5 August 2019

## **SECTION 4.55(1A) MODIFICATION APPLICATION TO SSD 16\_7919 - RESPONSE TO RFI 85 CARABELLA STREET, KIRRIBILLI**

This response to request for additional information is provided to address your email dated 1 August 2019. A response to each of the Department's queries is outlined below. This letter should be read in conjunction with the following attachments:

title
**Western Precinct Plans
Western Precinct Learning Hub - Lower
Ground 1 Plan**

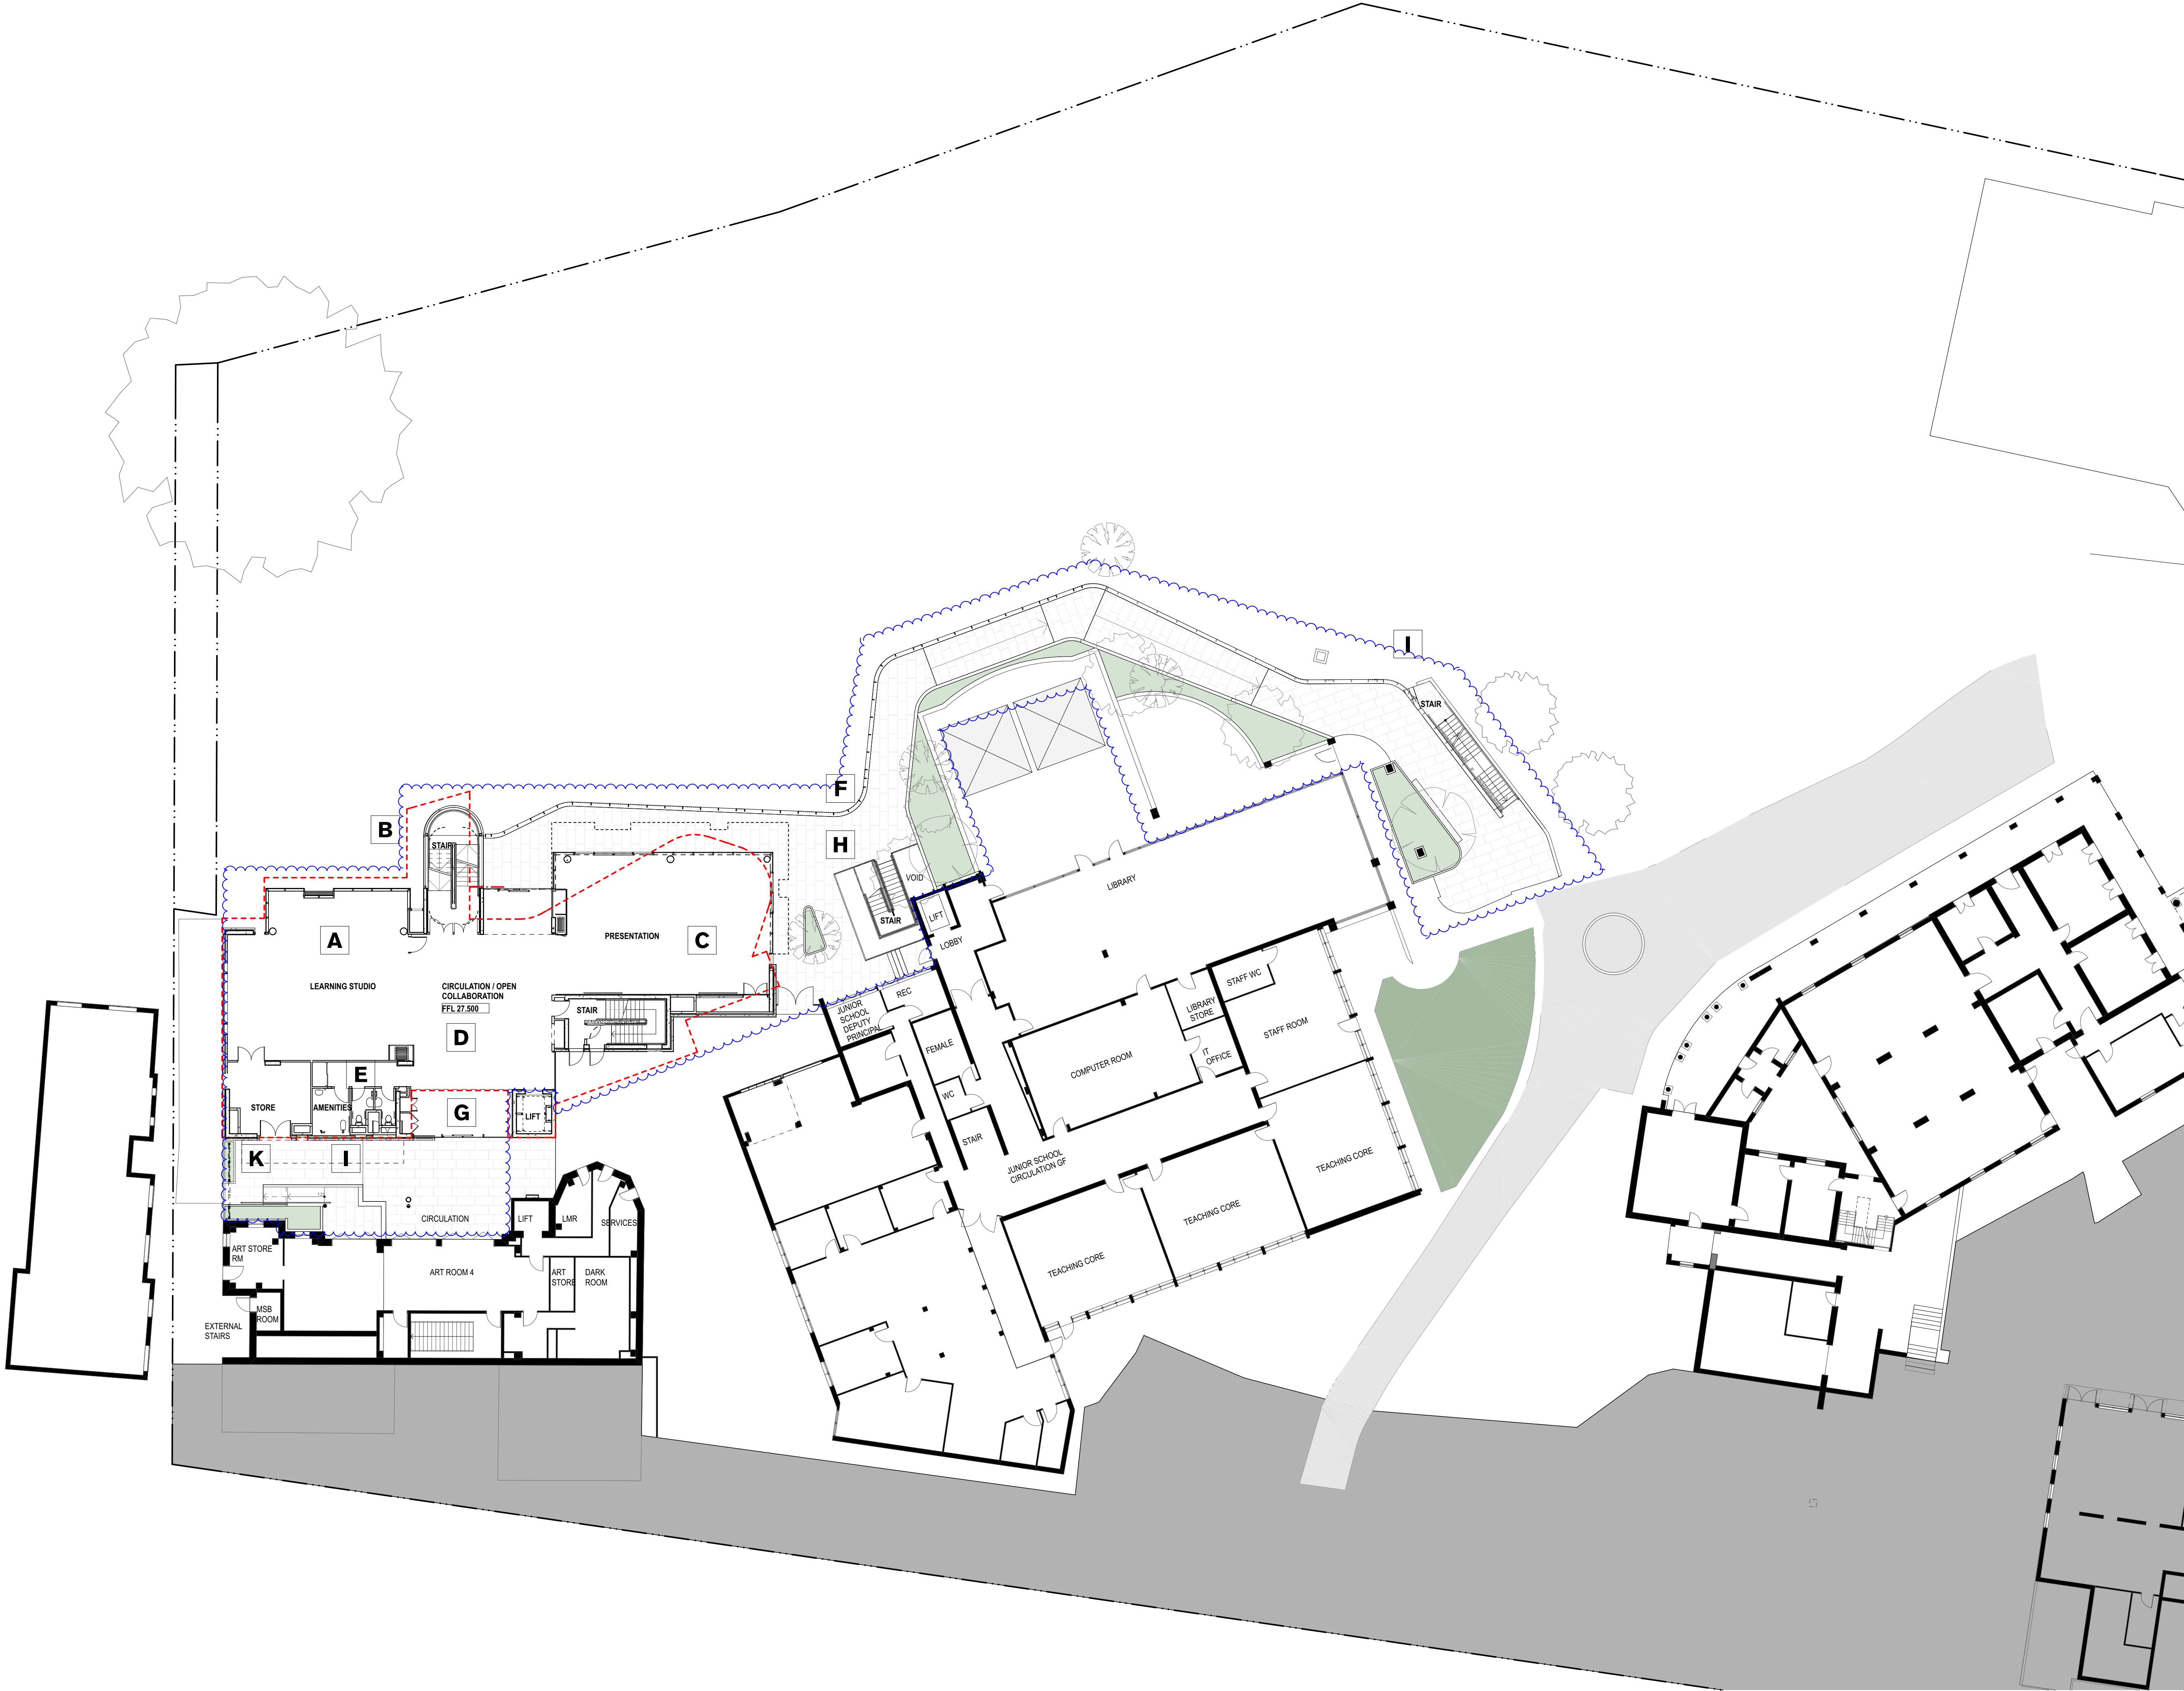
- *Whether the change in materials and the change in plan, especially the lower ground floor which now includes a huge area with no ventilation (PDHPE and weights), lead to any alterations to the ESD targets. While the design report states that the skylights would ventilate this, this is not a practical solution as no one will operate the skylights in the school on a daily basis and the new design of this floor completely eliminates natural light and ventilation which was previously provided (the glazed door and window are less than 1% of the floor area and not considered sufficient for this purpose).*

The lower ground level 4 is a large movement studio and weights area which is used in association with the gymnasium. The space replaces the current weights area which is located underneath the stage area of the Centenary Hall.

Previously, this area was a PDHPE learning area and the movement studio and weights area was located to the rear of the gymnasium to the east. This area will be used before and after school for co-curricular sports and during school for PDHPE. Due to the reduction in the extent of excavation, the learning studio function has been relocated to the refurbishment of the existing classrooms underneath the Chapel wing, with a shared use and the weights area relocated to the west. The previous external courtyard has been converted to an internal area, to address Condition B6.

As shown in **Figure 3**, in the SSD submission natural daylight and ventilation was not able to be provided in the movements and weights studio as a result of the disconnect with the external environment. The function of the revised weights area is divided into two zones - the zone to the south-east will have a raised acoustic floor to accommodate free weights and a sled track, the zone to the west will accommodate cardio equipment such as ergonometres for rowing training, exercise equipment such as running machines, cycles and steppers and a central circuit area. Not unlike a commercial weights gym, daylight is not essential for the function of this area. However, daylight has been provided via two large skylights and the northern glazed wall and door, which will improve the daylight condition when compared to the original SSD application, where there was no access to natural light or ventilation. A comparison between the approved and proposed location of the weights area and gym is provided at **Figure 3**.

The two skylights have been incorporated into the design to provide a connection with the environment, as will the glazing to the north. The function of the skylights is for daylight and not natural ventilation. An indicative view of the proposed weights area is **attached** and provided at **Figure 4**.
